DOC19/1097837

**Sydney Gateway Road Project (SSI 9737)  
Advice on the Environmental Impact Statement (EIS)**

## ATTACHMENT A: EPA COMMENT ON EIS FOR SYDNEY GATEWAY ROAD PROJECT (SSI 9737)

Figure 10.2 Sensitive receivers and noise monitoring locations

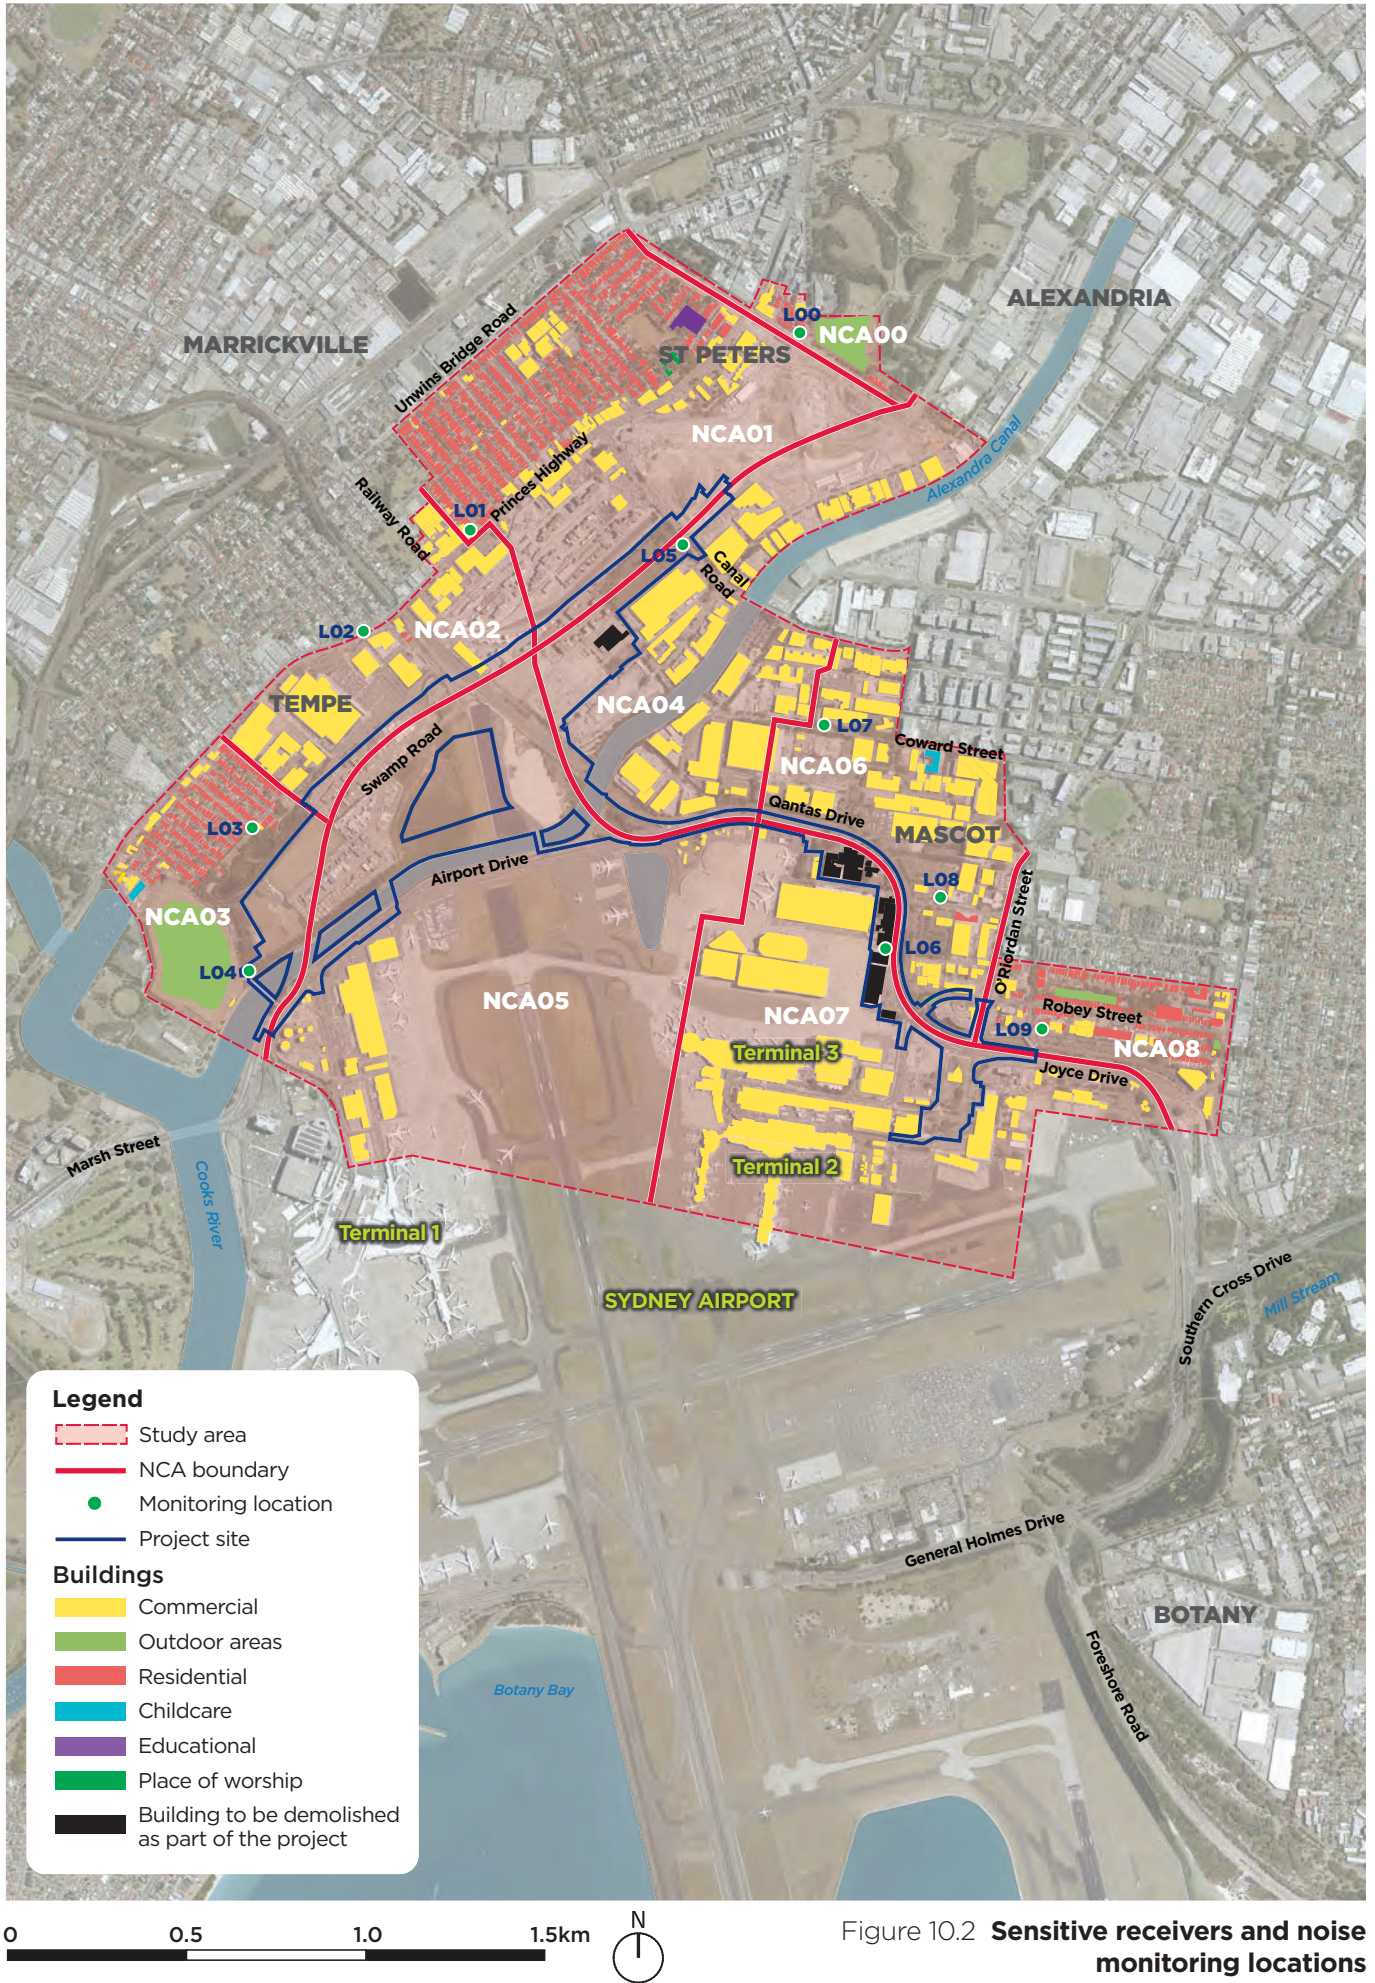
#### Noise monitoring

- a) Weather data in noise monitoring graphs appears to show that there were predominately calm winds during the monitoring period. However, reviewing the Sydney Airport Weather Station data for the period appears to indicate that some days, shown as calm in the monitoring graphs, had elevated wind speeds recorded at the station. **The proponent is requested to clarify the weather data used to process the noise monitoring data and amend the report accordingly.**

- b) The noise report did not provide a model validation point representative of receivers on Baxter Road. There are some receivers identified as eligible for treatment in this area, and the project is predicted to adversely impact noise levels at receivers as a result of generating additional traffic movements on Joyce Drive. Whilst some receivers on Baxter Road may be beyond the end of the geometric limit of the proposed changes, they have been assessed and represent the most affected sensitive receivers to the south of the project. **The proponent is requested to provide a justification for not validating the noise model in the Baxter Road area.**

Figure 10.4 Construction vibration assessment – buildings within minimum working distances

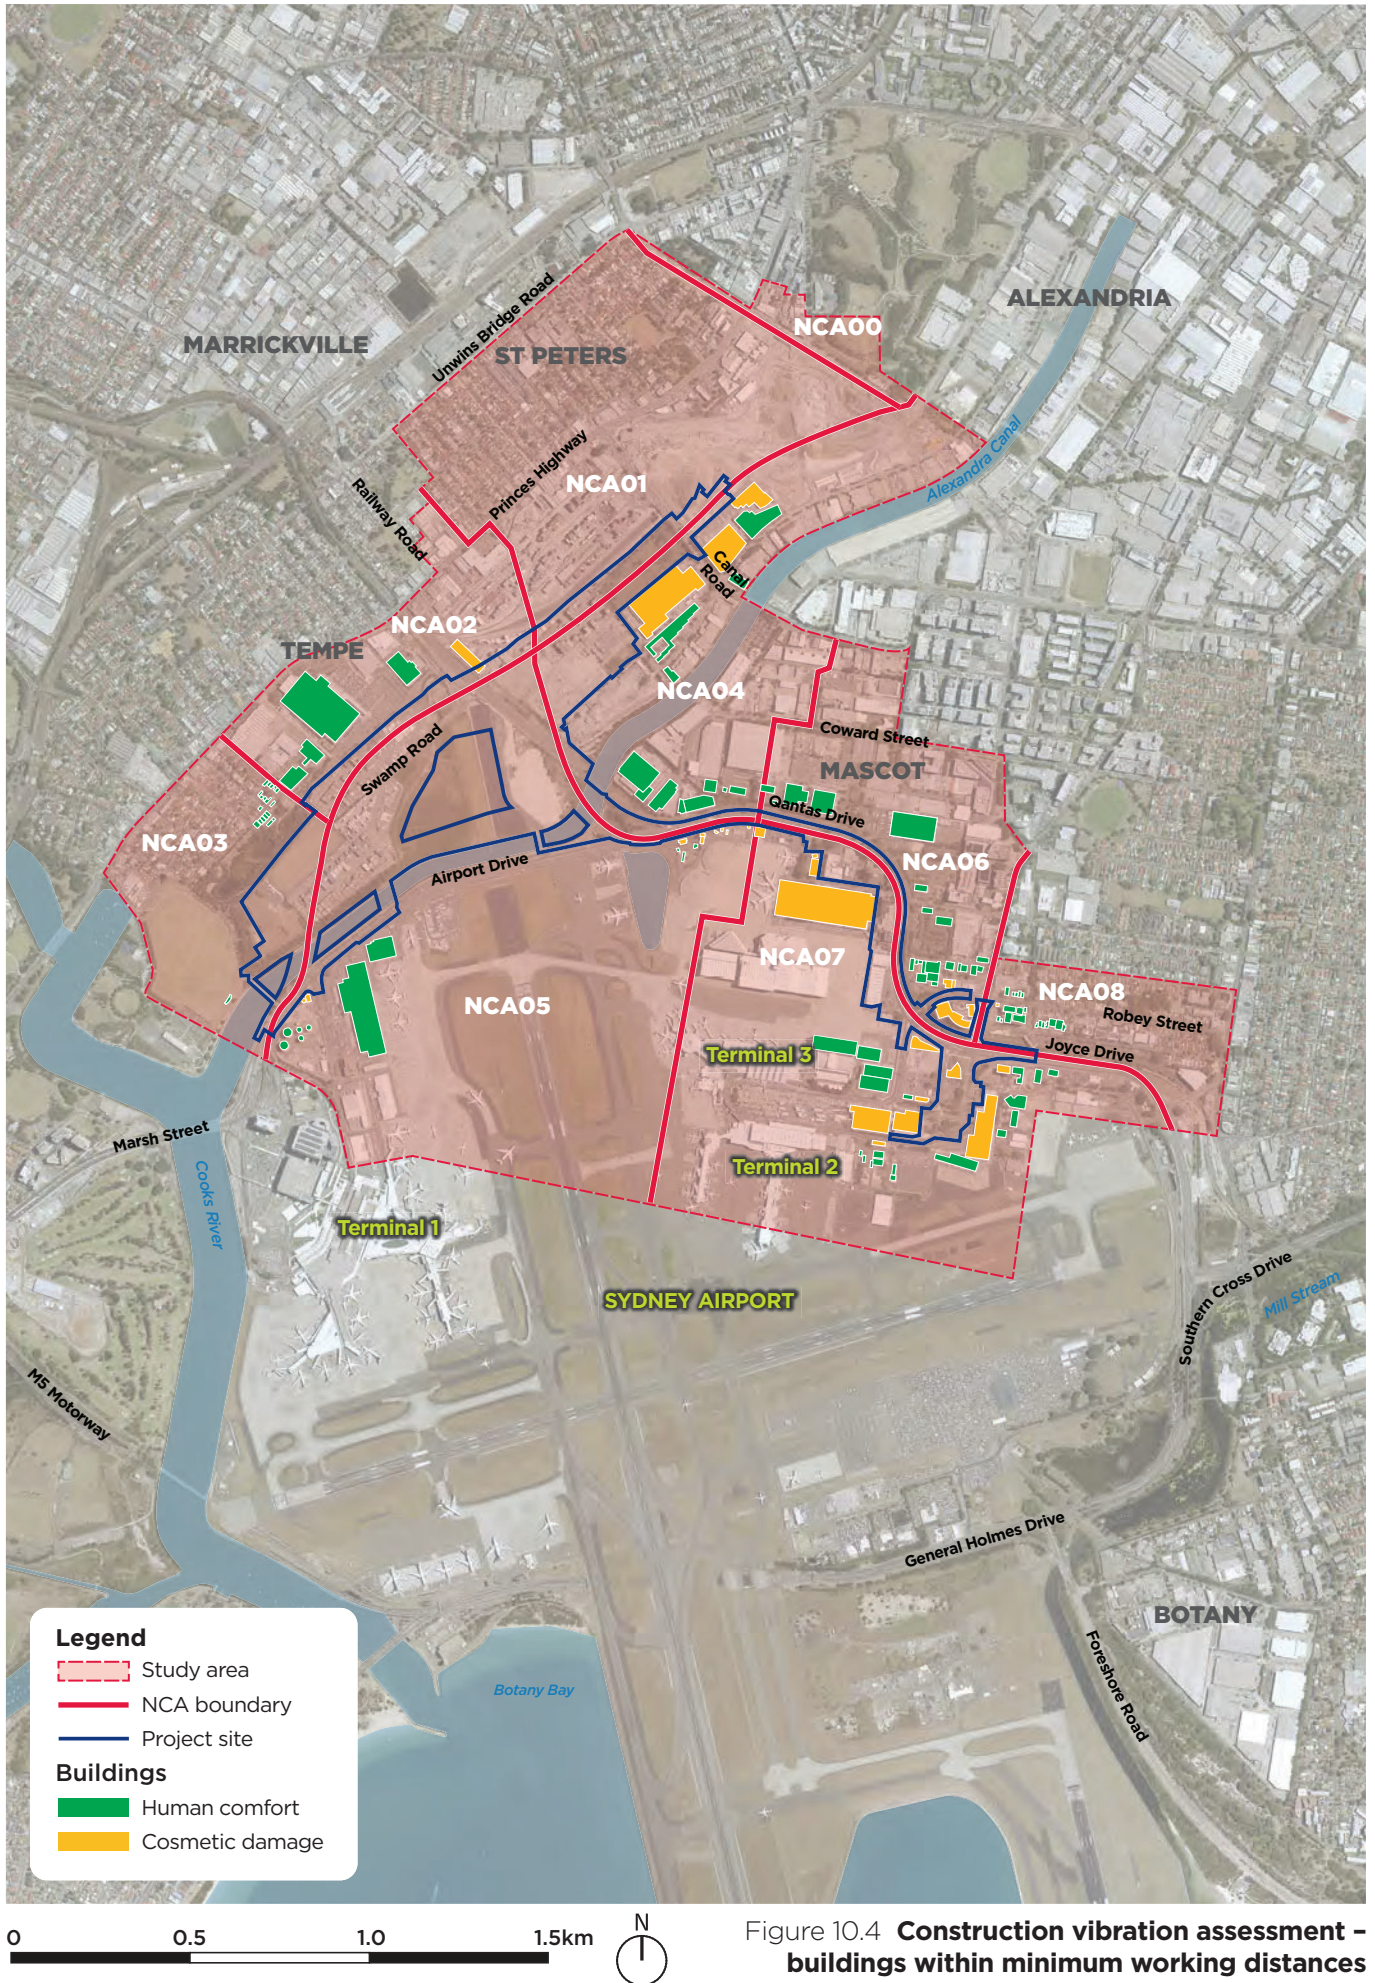
- a) **The noise report should provide an assessment of, and management options for potential vibration impacts due to dynamic compaction.**
- b) The proponent should engage with particularly sensitive receivers, such as the Qantas Flight Training Centre to determine appropriate limits for human comfort vibration and to determine particularly sensitive time periods and other areas of concern.

Figure 13.1 Contamination assessment areas

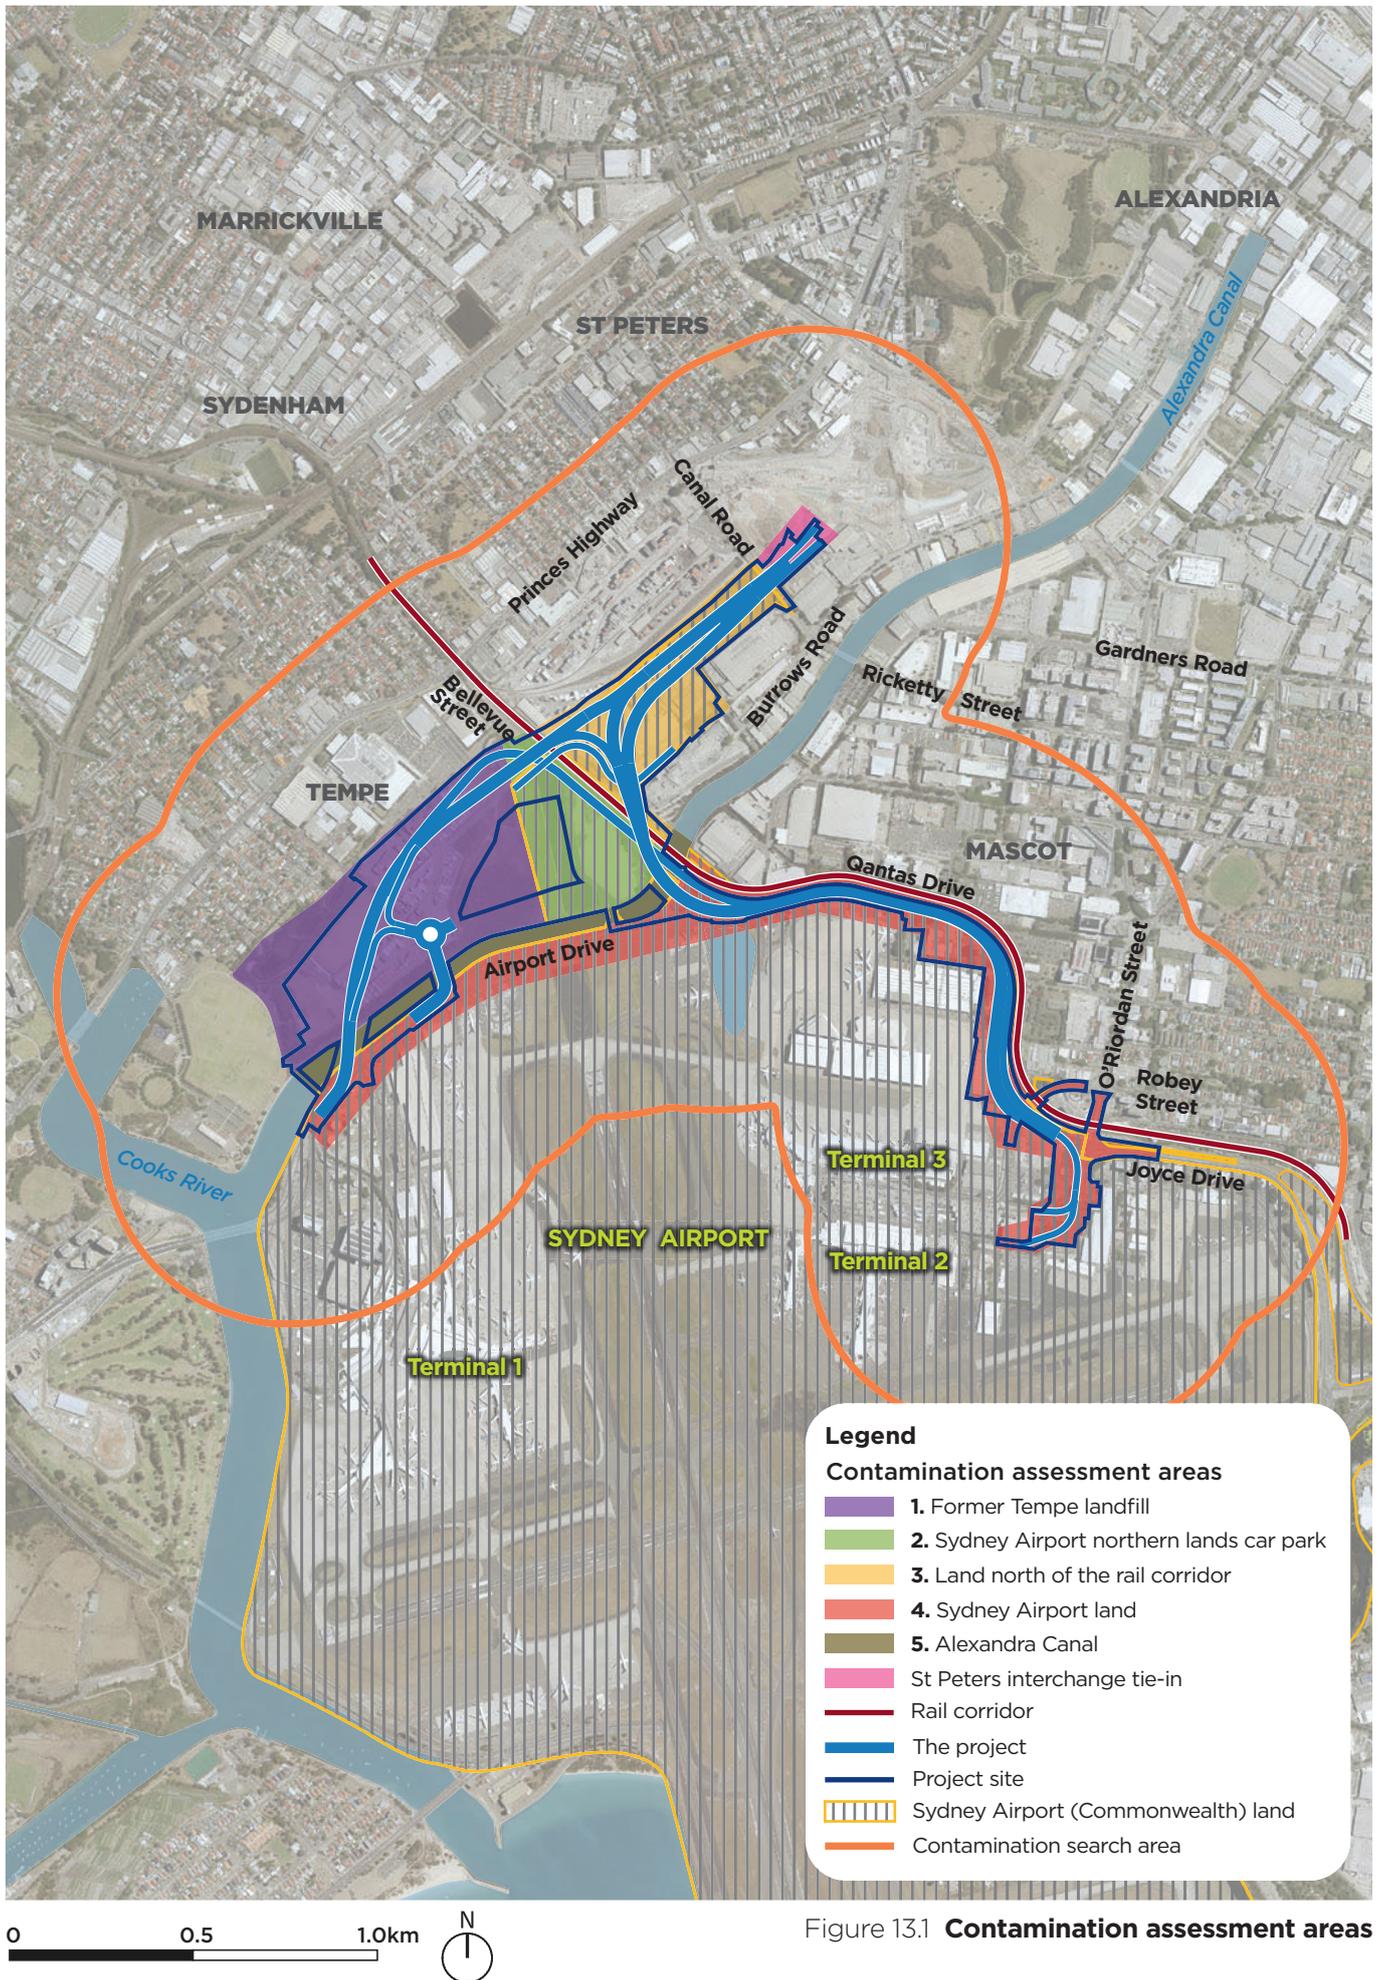
The areas of concern were identified as five distinct assessment areas with separate conceptual site models requiring special management, including potential remediation. These are:

- 1) Former Tempe Landfill
- 2) Alexandra Canal
- 3) Sydney Airport northern lands car park (Commonwealth land)
- 4) Land north of the rail corridor (Commonwealth land)
- 5) Sydney Airport land along Alexandra Canal and Qantas Drive (Commonwealth land)
